CITY OF ALBUQUERQUE

Re: Stanford Court
424 Stanford Dr., SE
Traffic Circulation Layout
Engineer's/Architect's Stamp 3-2-16 (K16-D084)

Based upon the information provided in your submittal received 3-29-16, the above referenced plan cannot be approved for Building Permit until the following comments are addressed:

19 Ryan Road Edgewood, New Mexico 87015 Tel: (505) 281-2444		LOT 12-A, BLK. 13, UNIVERSITY HEIGHTS ALBUQUERQUE, BERNALILLO COUNTY, NEW MEXICO	
DATE	REVISION	4/4/16	ADDR. TRAFF.
DESIGNED BY: PWC		TRAFFIC CIRCULATION	
CHECKED BY: PWC		LAYOUT PLAN	
DRAWN BY: COE		1 OF 1

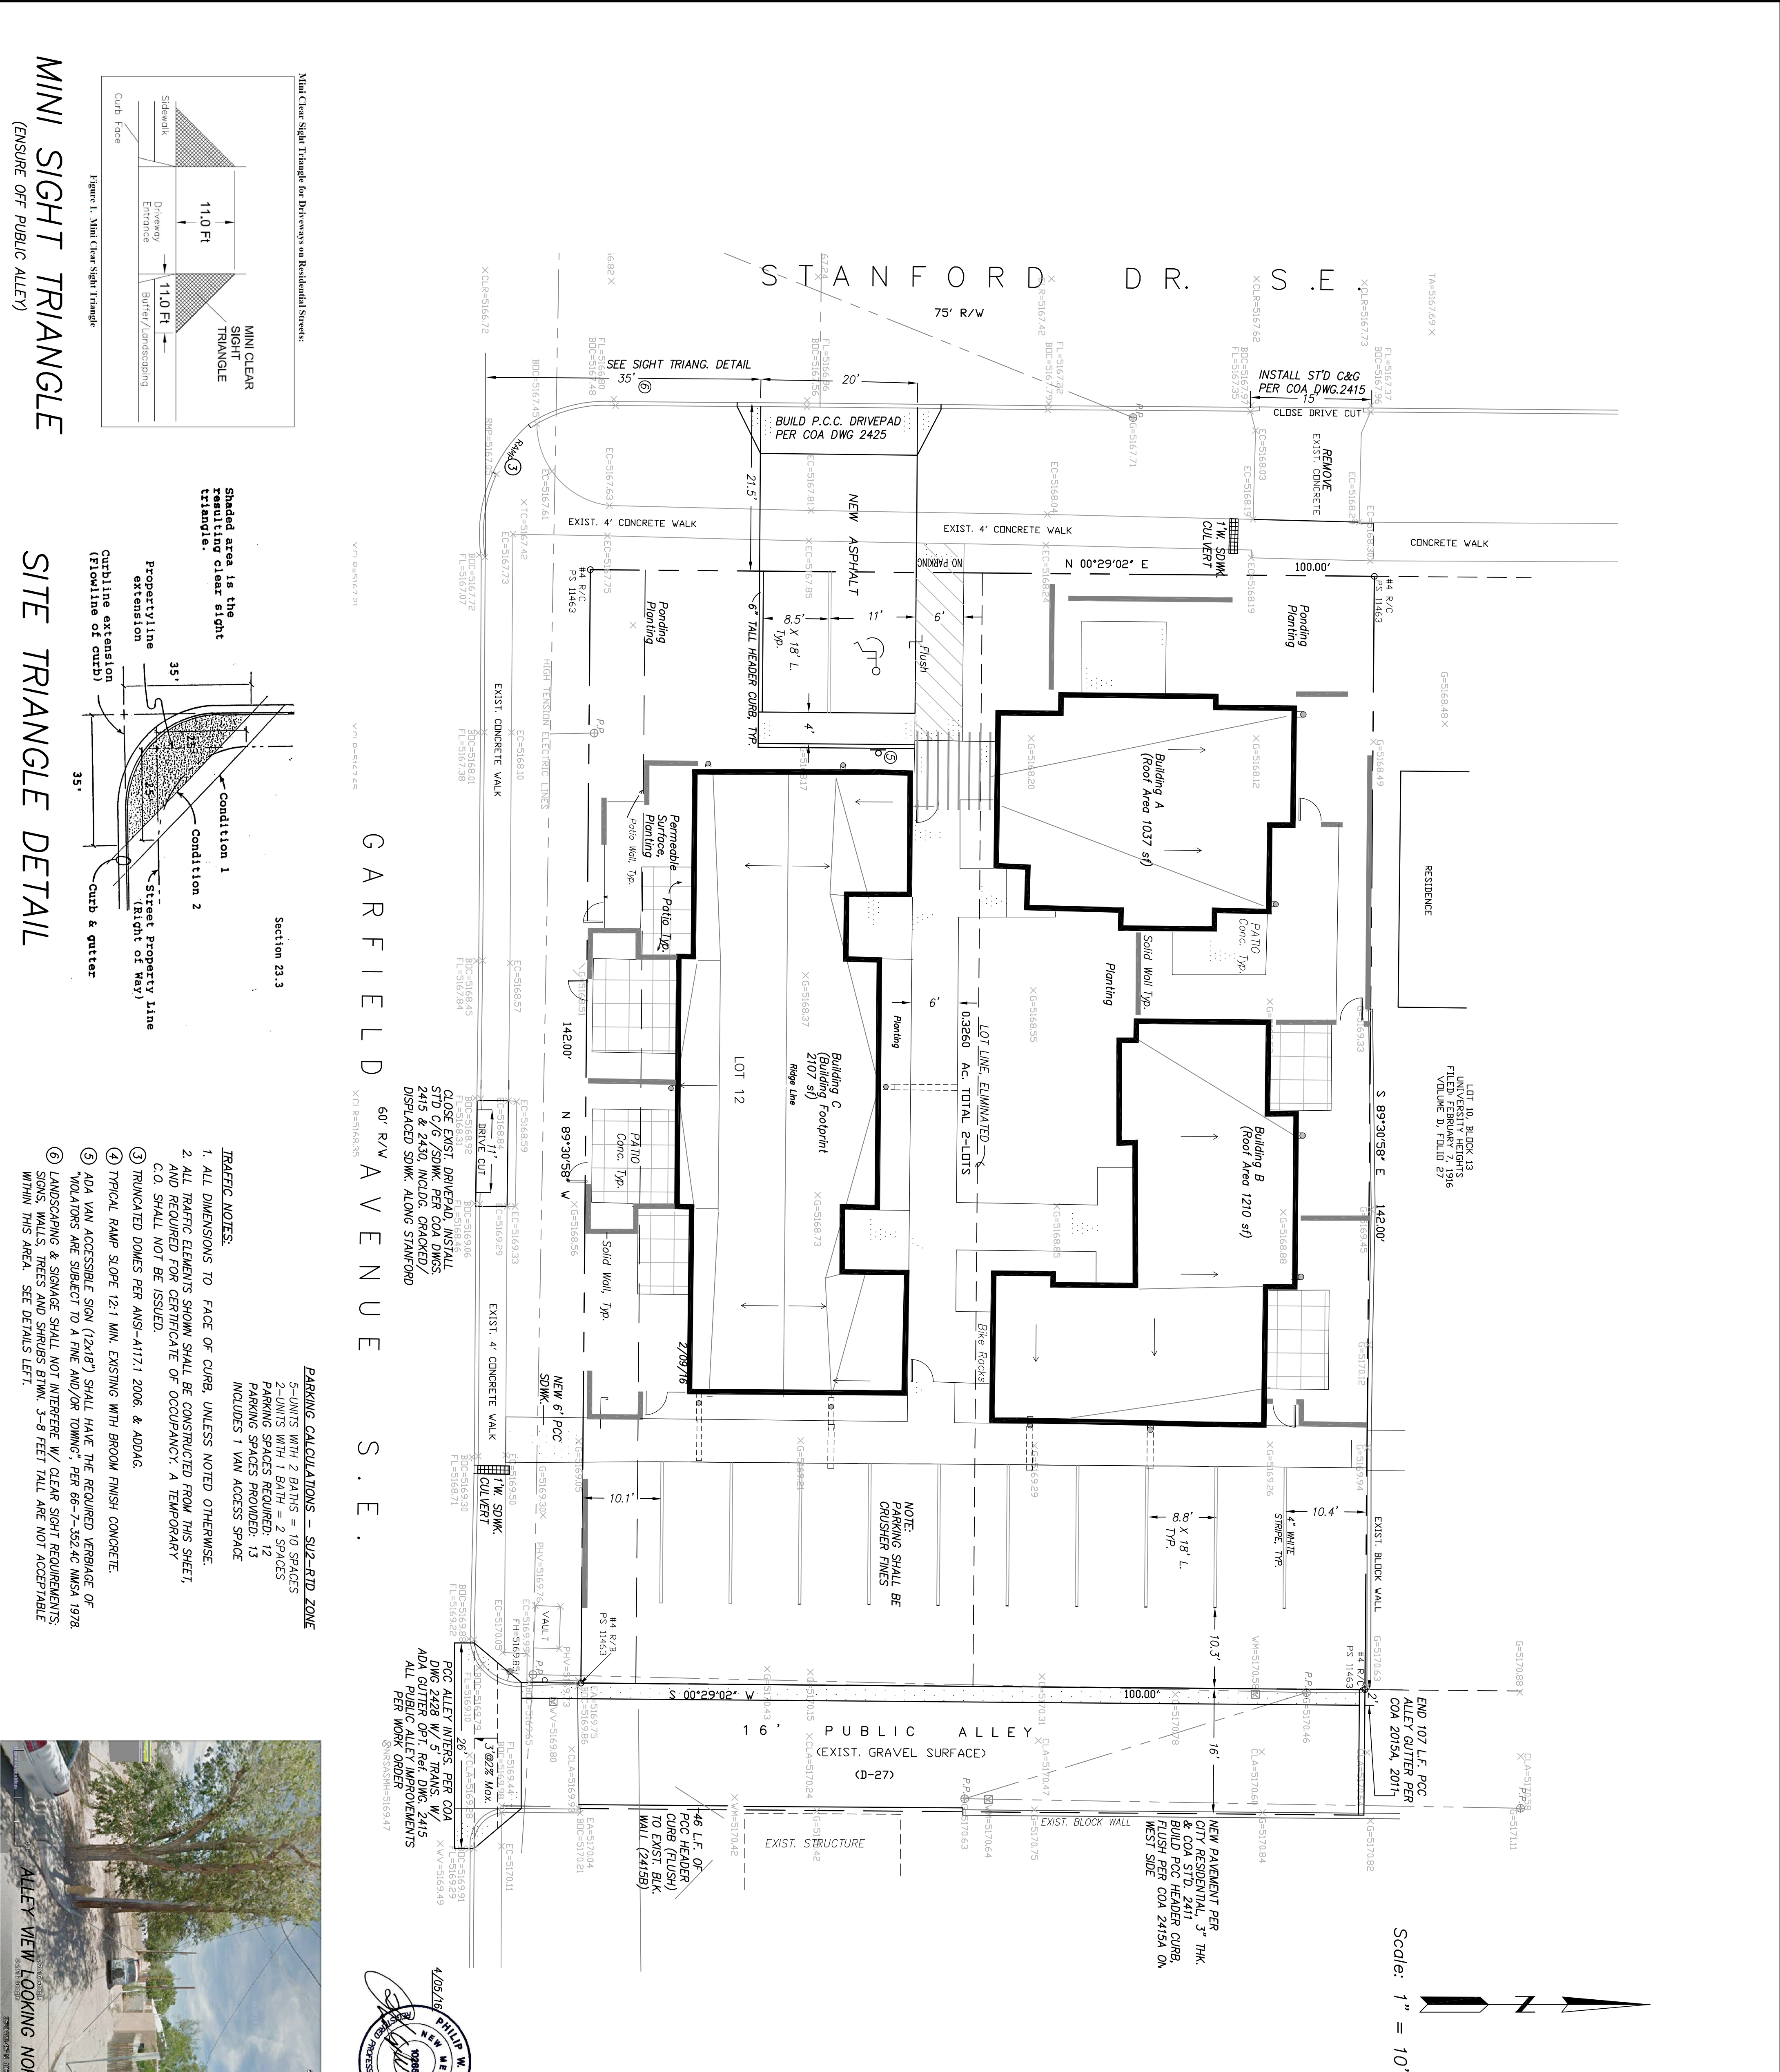
1. Please submit a separate TCL drawing not including hydrology details for clarity of traffic related details.
2. The handicap accessible spaces must include an 8 ft. wide van access aisle; all other aisles should be 5 ft. in width. Please clearly show the access aisle and hatching detail for this space.

3. The ADA accessible parking sign must have the required language per 66-7-352.4C NMSA 1978 **"Violators Are Subject to a Fine and/or Towing."** Please call out detail and location of HC signs.

4. The ADA access aisles shall have the words **"NO PARKING"** in capital letters, each of which shall be at least one foot high and at least two inches wide, placed at the rear of the parking space so as to be close to where an adjacent vehicle's rear tire would be placed. (66-1-4.1.B NMSA 1978)

5. Show all drive aisle widths and radii.
6. Per DPM, a 6 ft. wide ADA accessible pedestrian pathway is required from the public sidewalk to the building entrances. Please clearly show this pathway and provide details.

7. Per DPM, a 6 ft. wide ADA accessible pedestrian pathway is required from the HC parking stall access aisles to the building entrances. Please clearly show this pathway and provide details.

8. Provide a min 6" or max 8" high concrete barrier curb or other acceptable barrier between landscaping and parking areas and/or drive aisles. Please call out detail and location of barrier curb.

9. A hard driving surface will be required as part of this proposed project for the parking area and drive aisle in the alley. Please call out detail stating to "See City Work Order" for work to be done in the public alley.

10. Please provide a sight distance exhibit (see the *Development Process Manual, Chapter 23, Section 3, Part D.5 Intersection Sight Distance*). Please clearly dimension the distance from the intersection of Stanford Dr. and Garfield Ave. to the proposed new curb cut on Stanford Dr.

11. Please provide a Mini Clear Sight distance exhibit (see the *Development Process Manual, Chapter 23, Section 3*), for the entrance/exit off of the public alley on the east side of the project site.

12. Please add the following note to the clear sight triangle: "Landscaping and signage will not interfere with clear sight requirements. Therefore, signs, walls, trees, and shrubbery between 3 and 8 feet tall (as measured from the gutter pan) will not be acceptable in this area."
13. All broken or cracked sidewalk must be replaced with sidewalk and curb & gutter. A build note must be provided referring to the appropriate City Standard drawing.
14. Please include two copies of the traffic circulation layout at the next submittal.
